**From:** Gerring, Anna (MMO)  
**Sent:** 03 August 2012 14:45  
**To:** 'Mike Harris'  
**Cc:** McNiven, Gregor (MMO)  
**Subject:** Able UK - TR030001 - MMO [REDACTED] comments on WRs and responses to comments on RRs

**The Able Marine Energy Park Development Consent Order 2012**

**THE ABLE MARINE ENERGY PARK DEVELOPMENT CONSENT ORDER 2012**

**COMMENTS ON WRITTEN RESPONSES AND RESPONSES TO COMMENTS ON  
RELEVANT REPRESENTATIONS**

Figure 2.3: Long Term changes in bed Levels at the Centrica and Eon Intake and Outfalls

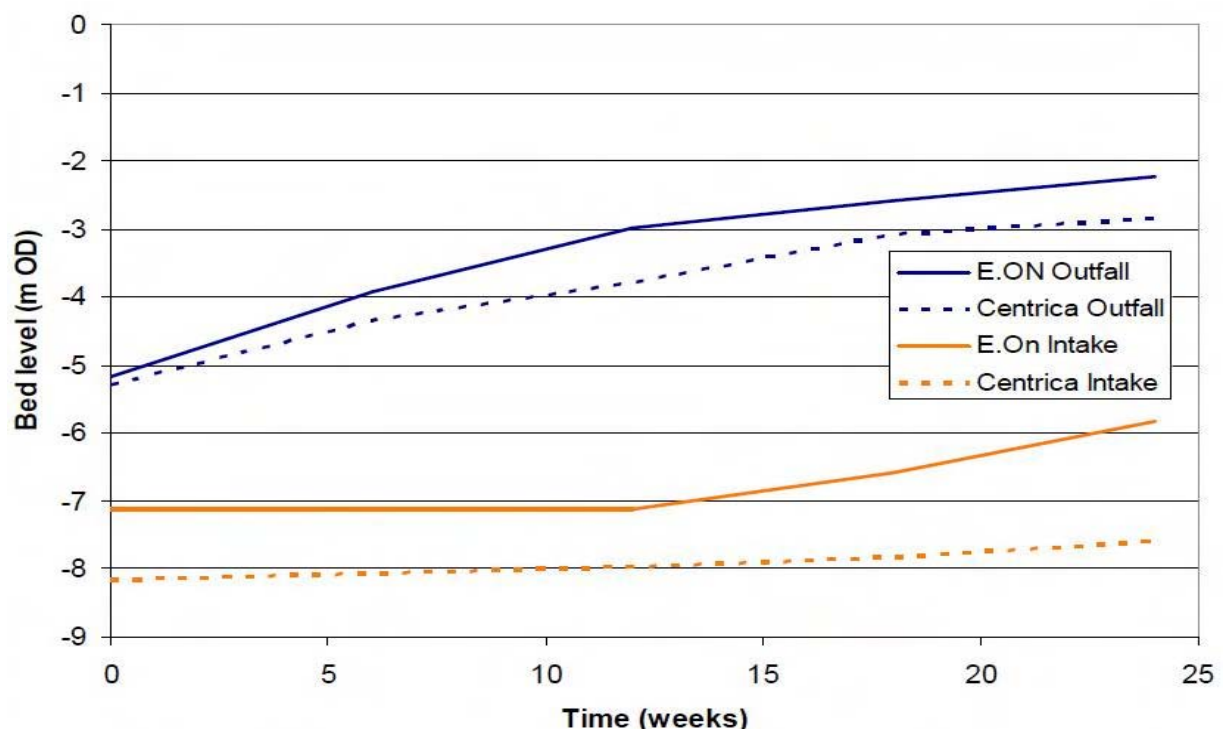
No	MMO	Able UK	MMO comments
	<p>values provided.</p>	<p>initially.</p> <p>Plough dredging is mentioned in Annex 7.6 as possible mitigation for the Centrica outfall. Work undertaken post submission is presented in HRW Technical Note DHR 4808-1 shows only the E-ON outfall is likely to be smothered and will need to be diverted. The frequency of plough dredging at the Centrica outfall is difficult to estimate; it should be subject to an agreed monitoring programme.</p> <p>The impact of the scheme on sedimentation in Stone Creek is assessed in Annex 32.4, Section 4.5 of the ES. Siltation is not expected to change as a consequence of the scheme. Nevertheless, an effect cannot be excluded due to the uncertainty attached to hydrodynamic modelling. Accordingly paragraph 4.5.5 recommends monitoring of sediment levels. Routine maintenance dredging is currently undertaken by the EA with (we understand) contributions from landowners and we would expect this to continue. It is considered that there is only a slight risk that the frequency of dredging operations increases due to the</p>	<p>contained in our relevant representations.</p> <p>I understand you are not now seeking permission to dredge Stone Creek.</p> <p><u>03-08-12</u></p> <p>The Applicant has confirmed the volumes of material they wish to dredge and dispose of to sea in the Statement of Common Ground (SOCG) between the Applicant, the MMO, Natural England and the Environment Agency submitted to the Examining Authority on 27 July 2012.</p> <p>Proposed volumes for capital dredge and disposal are provided in Table 12.2 of the SOCG and proposed volumes for maintenance dredge and disposal are provided in Table 12.3 of the SOCG.</p> <p>The MMO is currently undertaking an assessment of the dredge and disposal elements based on these</p>
